## 1.0 Landscape

This response is made with primary reference to document AP-044 3.1.32 Environmental Statement Chapter 30 Landscape and Visual Impact Assessment, and documents AP-083 to AP-088, 3.2.26 Environmental Statement Chapter 30, Figures Part 1 to 6.

The key elements of North Falls project include the proposed Offshore Wind Farm, the Onshore Substation (OnSS), onshore Export Cable Corridor (onshore ECC) and the landfall (where the offshore export cables will meet the onshore export cables).

Visualisation showing cumulative development, including year 1 planting - (90 degree view)

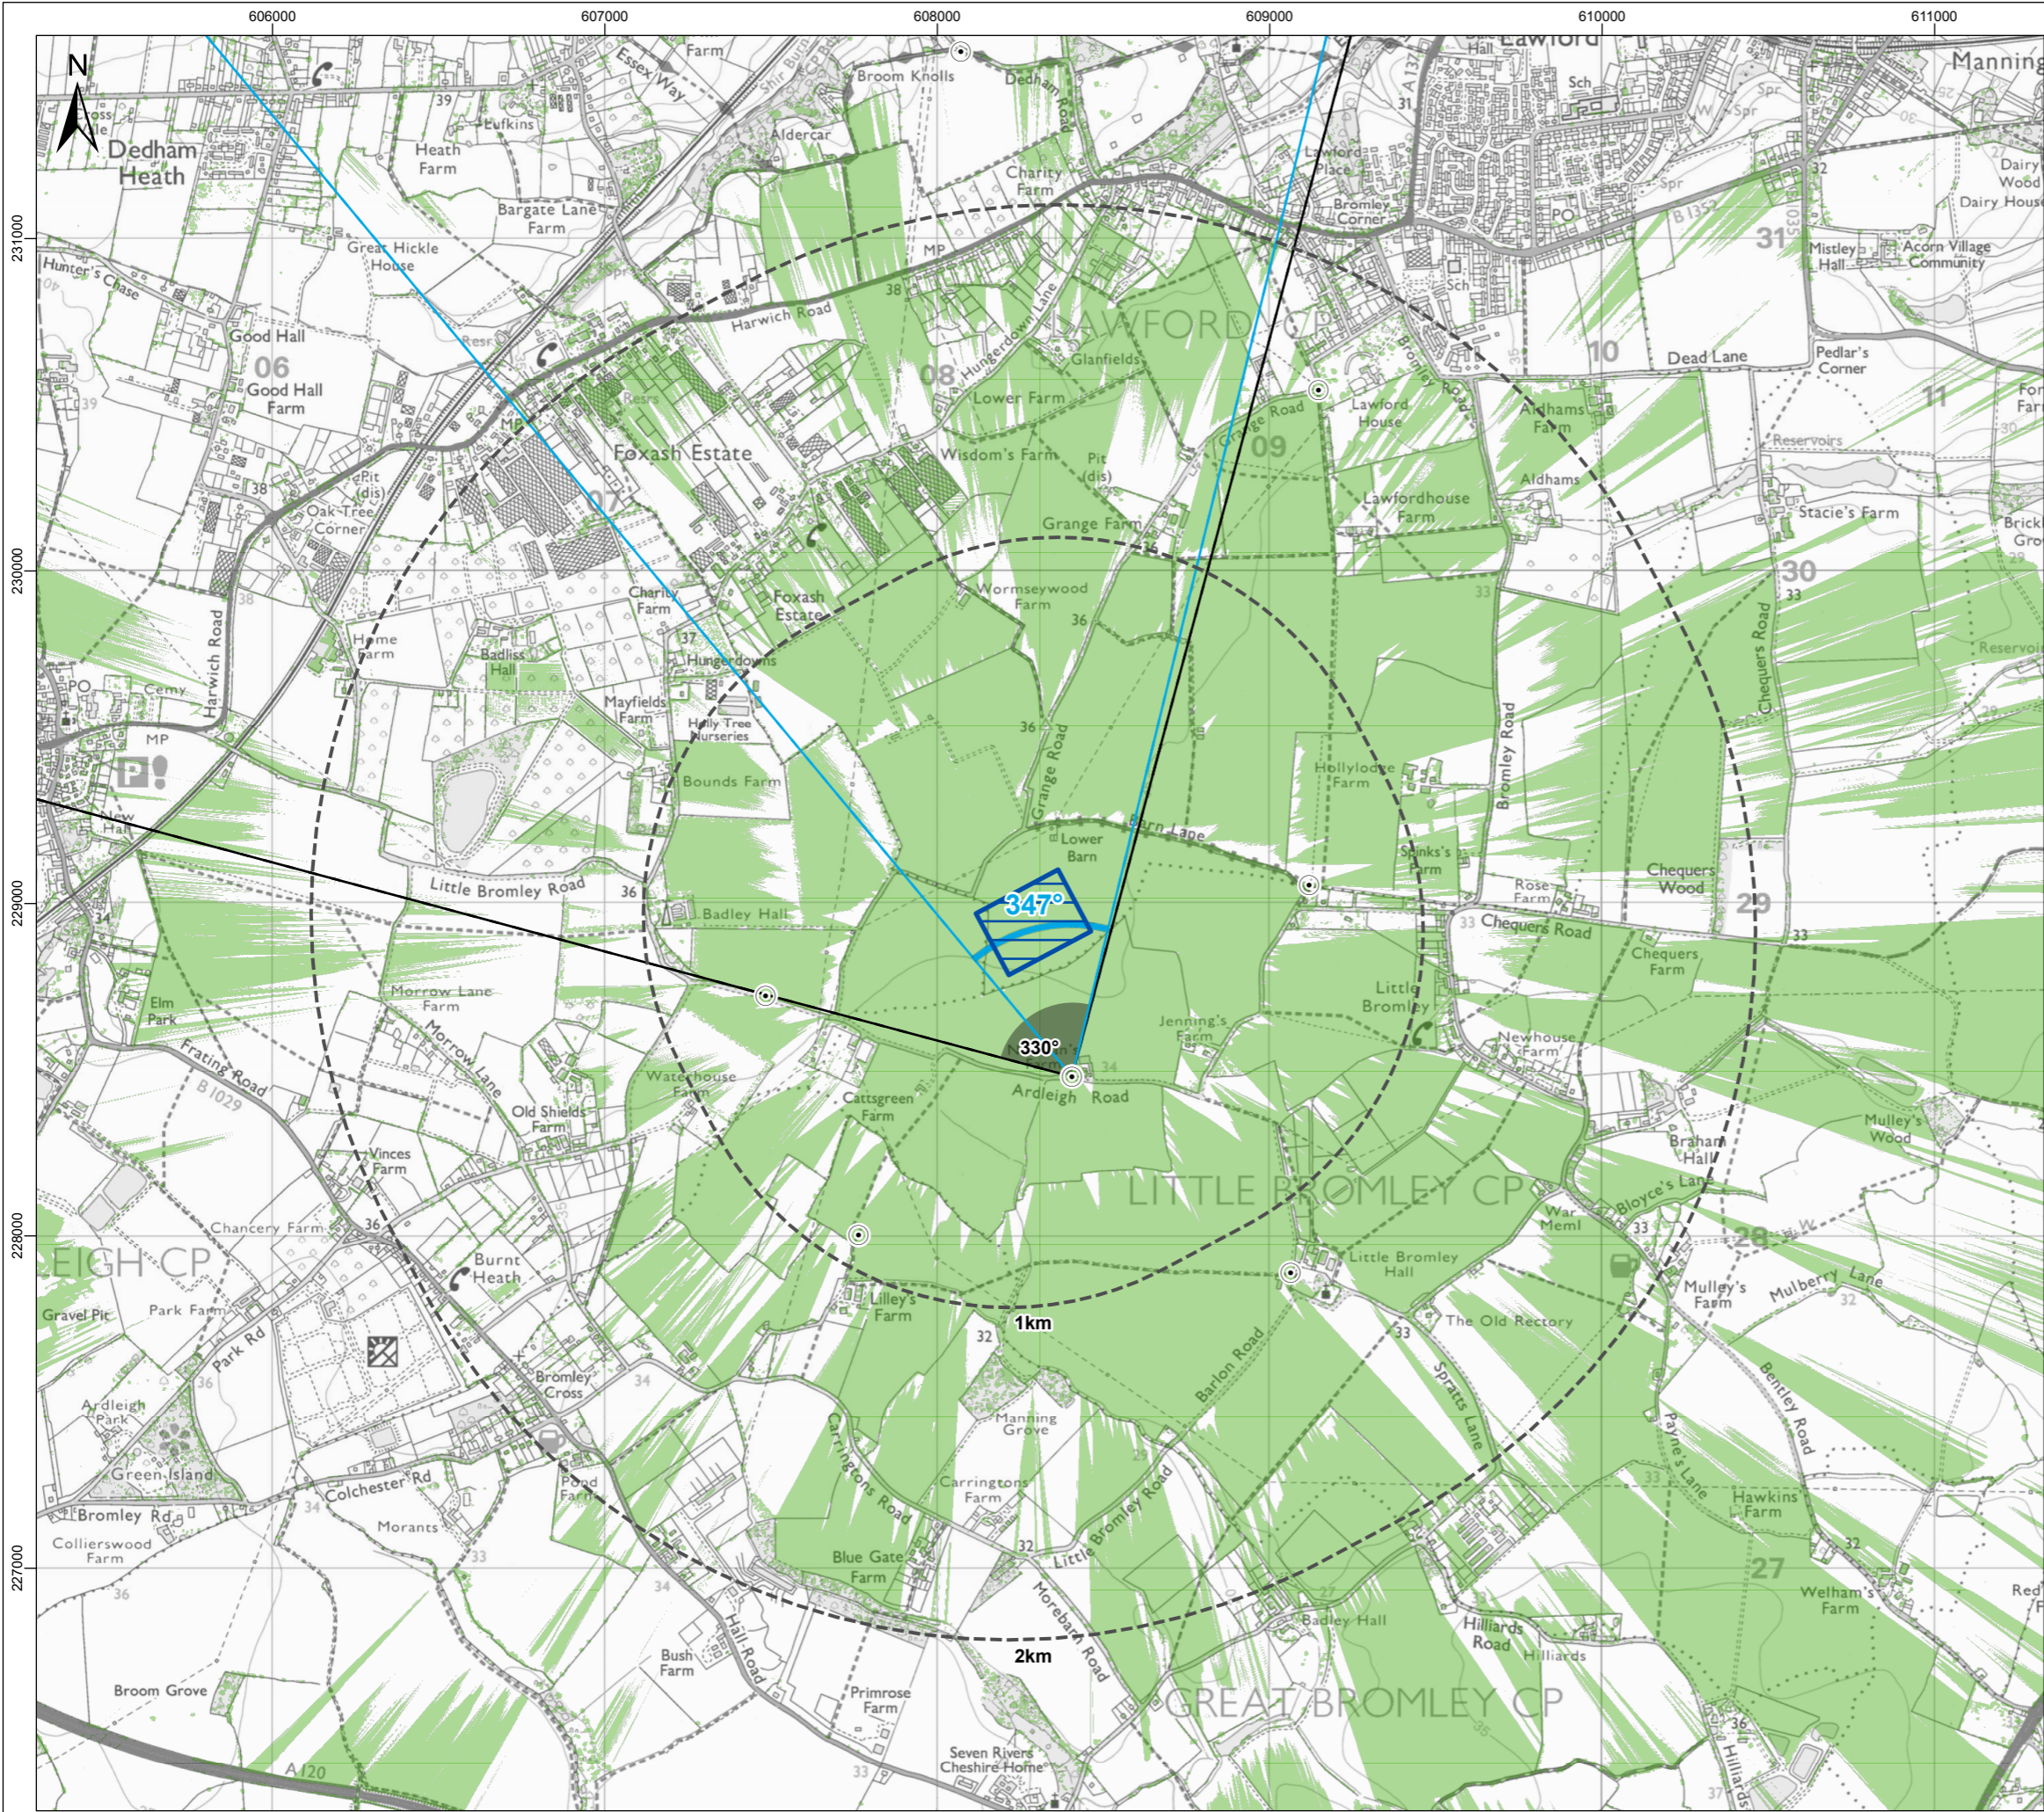
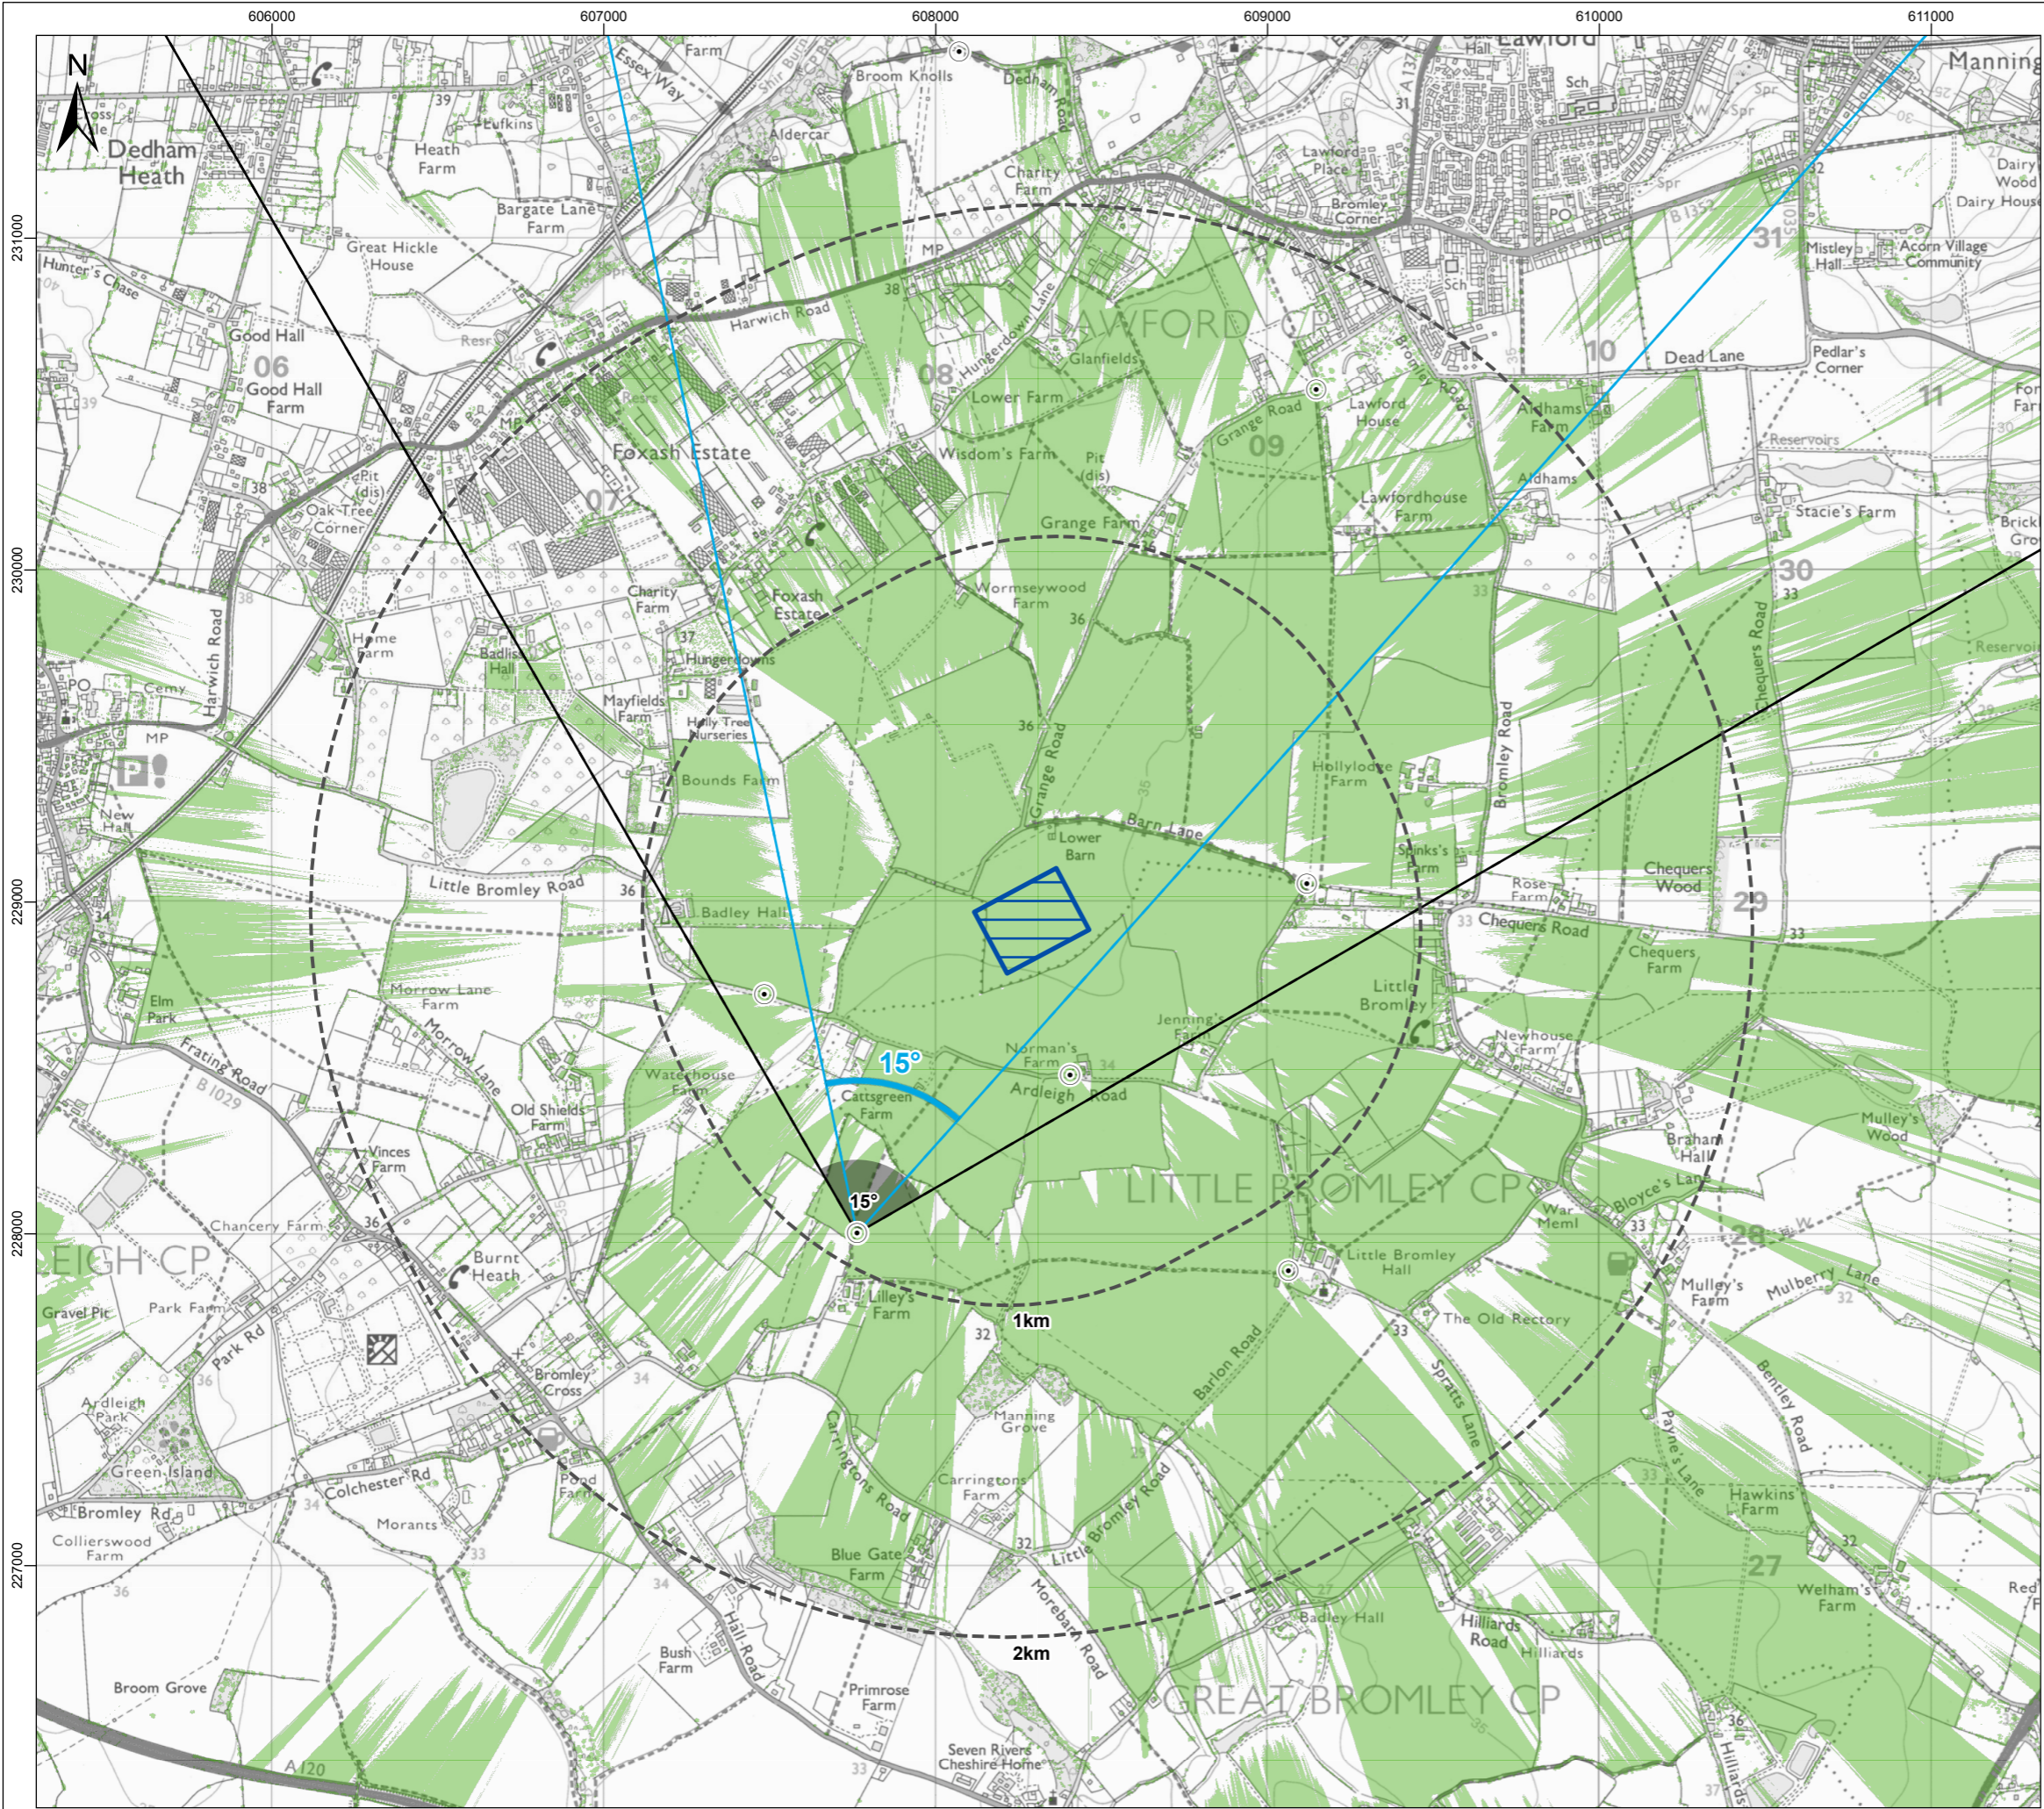
The N2T pylons do not appear to be identified in the cumulative LVIA visualisations, and therefore it is assumed they haven't formed part of the LVIA cumulative impact assessment itself. The pylons form will form part of the DCO for the Norwich to Tilbury project, along with the EACN so their cumulative impact needs to be considered.

GLVIA3 (Landscape Institute and Institute of Environmental Management and Assessment, 2013) defines cumulative landscape and visual effects as those that '*result from additional changes to the landscape and visual amenity caused by the proposed development in conjunction with other developments (associated with or separate to it), or actions that occurred in the past, present or are likely to occur in the foreseeable future.*' However, it is clear that the overhead element of the Norwich to Tilbury proposals have not been included in the visualisations provided with the assessment so we assume have not been assessed. The overhead pylons need to be included in the visualisations and the cumulative impacts re-assessed.
